Your Ref: OWPC13258
Our Ref: LU/52/17/NMA
Please ask for:
Mrs A Gardner

21st March 2017

**Section 96A of the Town & Country Planning Act 1990 (as amended)
Town and Country Planning (Development Management Procedure) (England) Order 2015
(as amended) - Article 10**

Application for non-material amendment following a grant of planning permission LU/314/16/PL relating to re-orientation of the building to the East, amendments to internal layout at ground & first floor levels. Removal of mezzanine floor level with the plant being distributed throughout the remaining building envelope. Reduction in overall width of the building by 1m. Reduction in overall floorspace and loss of one no. toilet. Reduction in maximum building height. Reduction in width of main swimming pool. Amendments to proposed car parking arrangement & amendments to energy strategy.
Littlehampton Swimming & Sports Centre Sea Road Littlehampton

Figure 9: Proposed ground floor plan

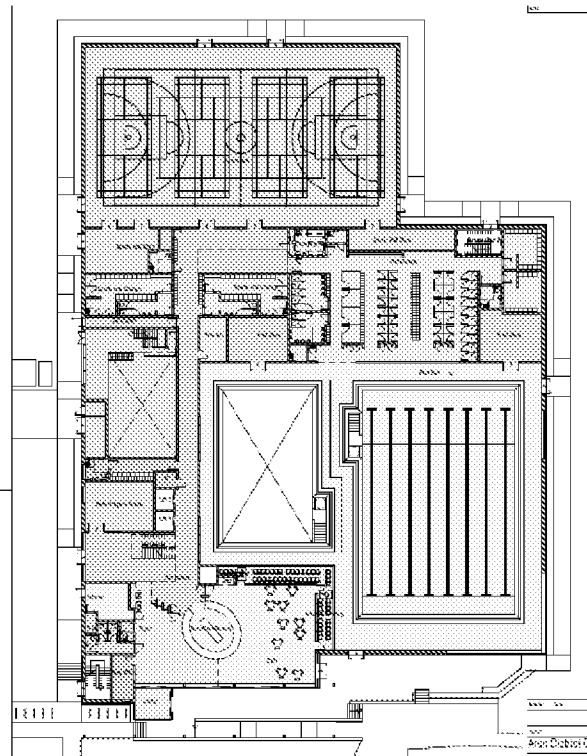
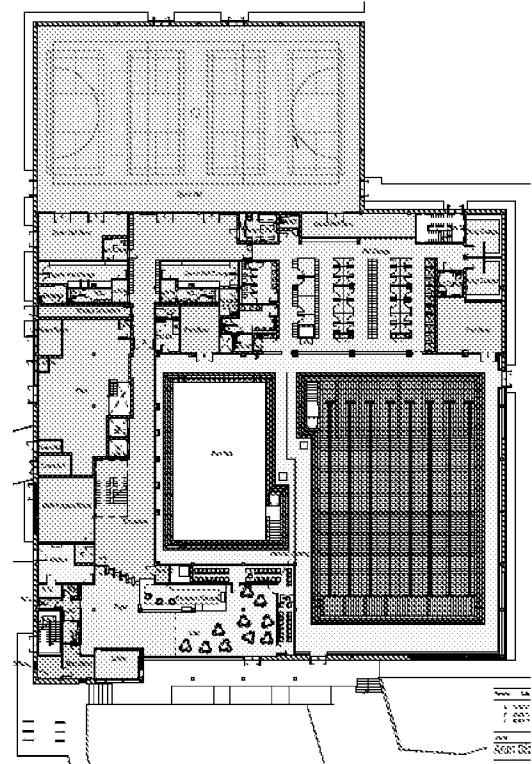
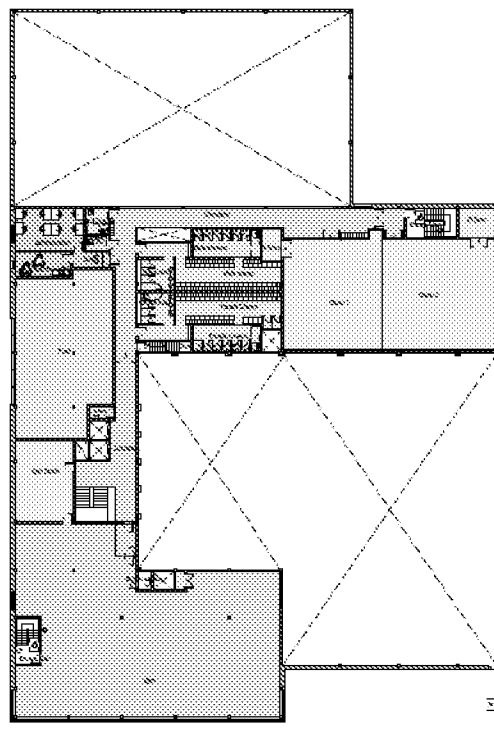
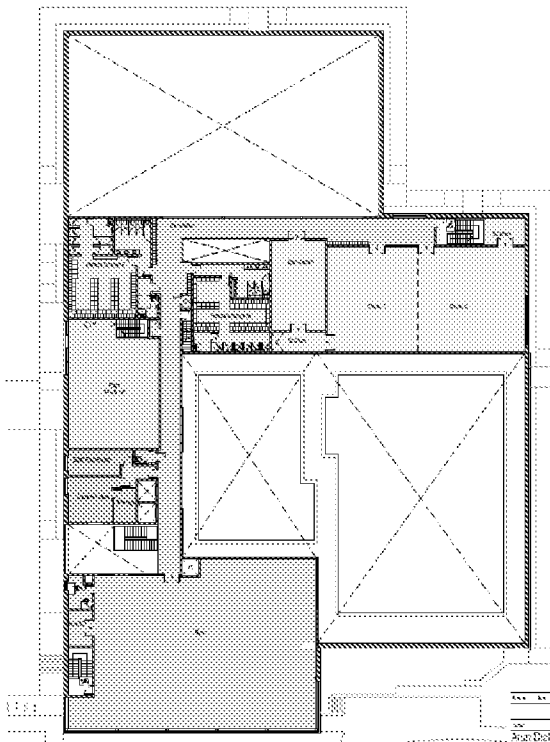
70.2.3 Observing that the internal configuration of facilities would result in reduced public toilet provision, Members questioned the viability of any proposals that might come forward in the future regarding the potential relocation of the Mewsbrook Park public conveniences with the new centre were no longer viable. It was unclear from the application what the impact would be of the reduction in the width of the swimming pool. Members were therefore concerned that any changes could result in the down-grading of the pool which might disadvantage local clubs who wished to participate in competitions at a higher level. It was also noted that the reduced footprint had provided the scope to improve the number of parking spaces and Members wished to ensure that coach parking and the bus stop for the new bus service had not also been sacrificed to achieve this. It was therefore agreed that clarification be sought on these aspects of the proposals.
